Current Zoning: R-17MF(CD) (multi-family residential, conditional)
Proposed Zoning: R-22MF(CD) (multi-family residential, conditional)

Approximately 4.2 acres located on the east side of West W.T. Harris Boulevard, north of Interstate 485, and south of Mt. Holly-Huntersville Road.

The petition proposes to allow up to 92 multi-family residential units on a vacant parcel previously rezoned via petition 2019-184 to permit up to 71 age restricted multi-family units in a single building.

STAFF RECOMMENDATION

RZ1.00

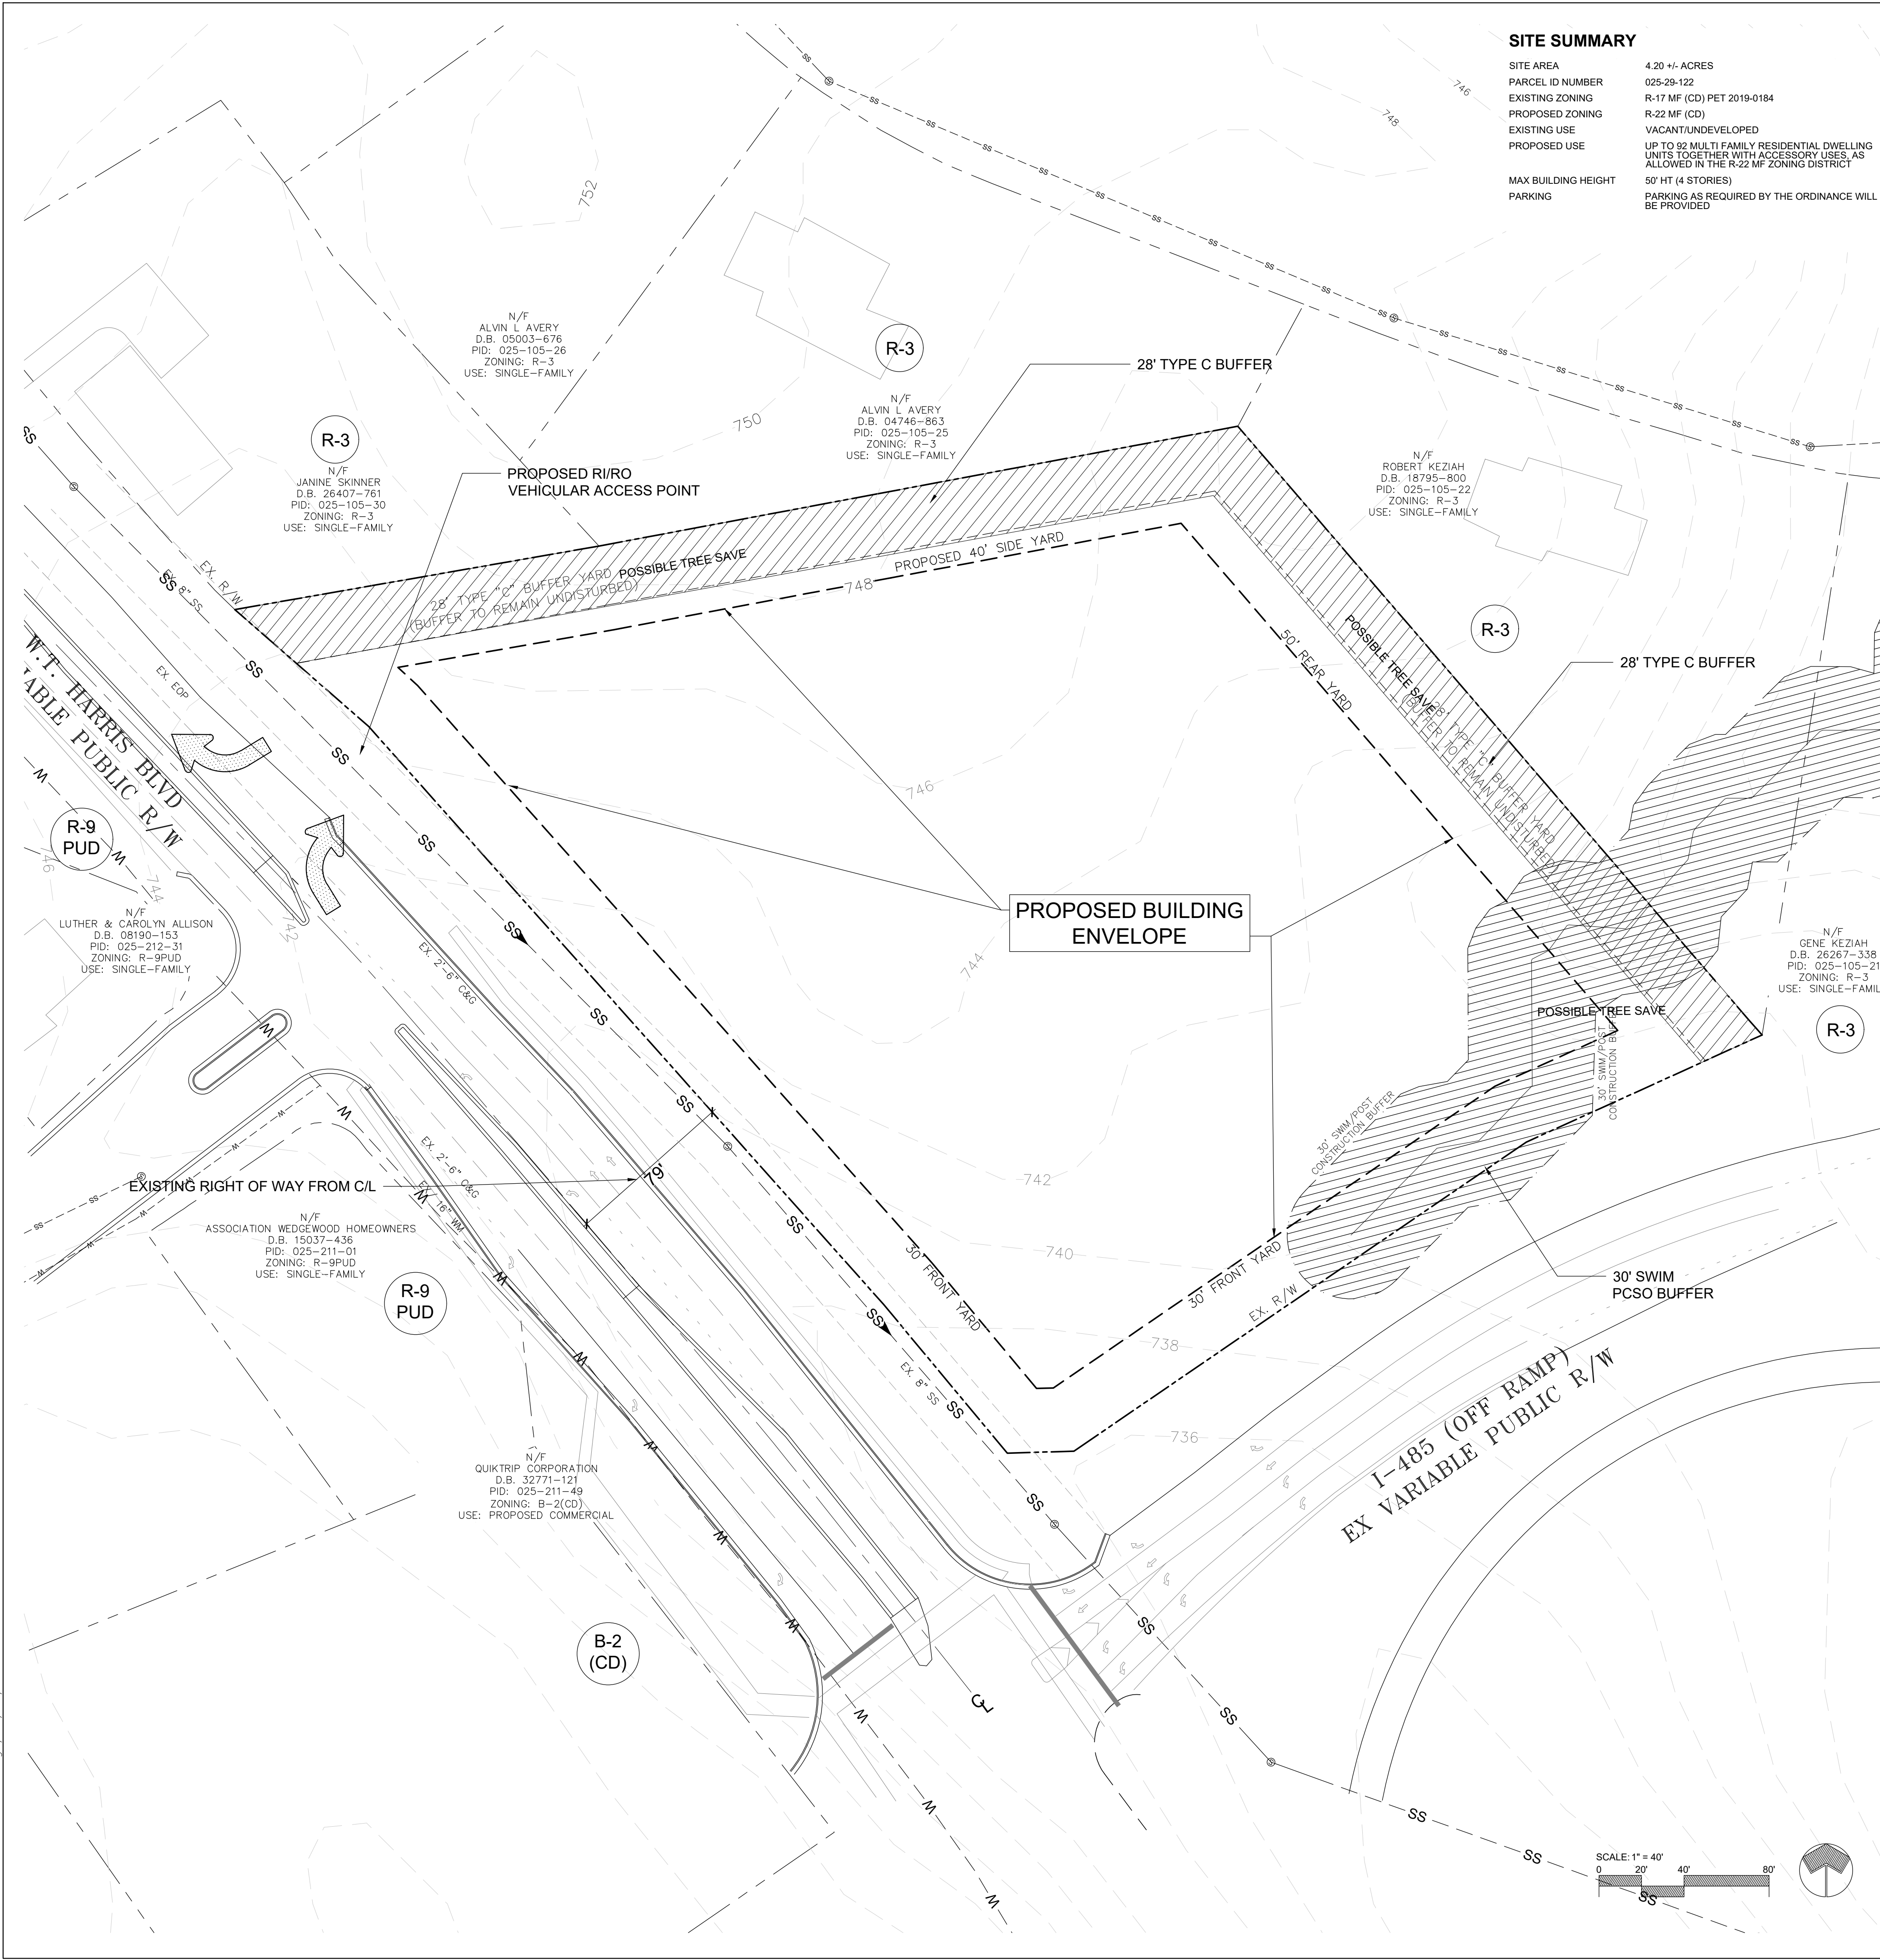
1. Label and dimension curb and gutter on the site plan.
2. A site plan note specifying that all transportation improvements will be approved and constructed before the site's first building certificate of occupancy is issued as needed. The petitioner may phase transportation improvements if said improvements and phasing are explicitly described in site plan notes. Remove existing conditional note 3D.

3. Increased yards will need to be provided per the ordinance for the increased height abutting single family residential zoning.
4. Development Note D.1. proposes two principal buildings, but one building is illustrated on the site plan. Please ensure information is consistent.
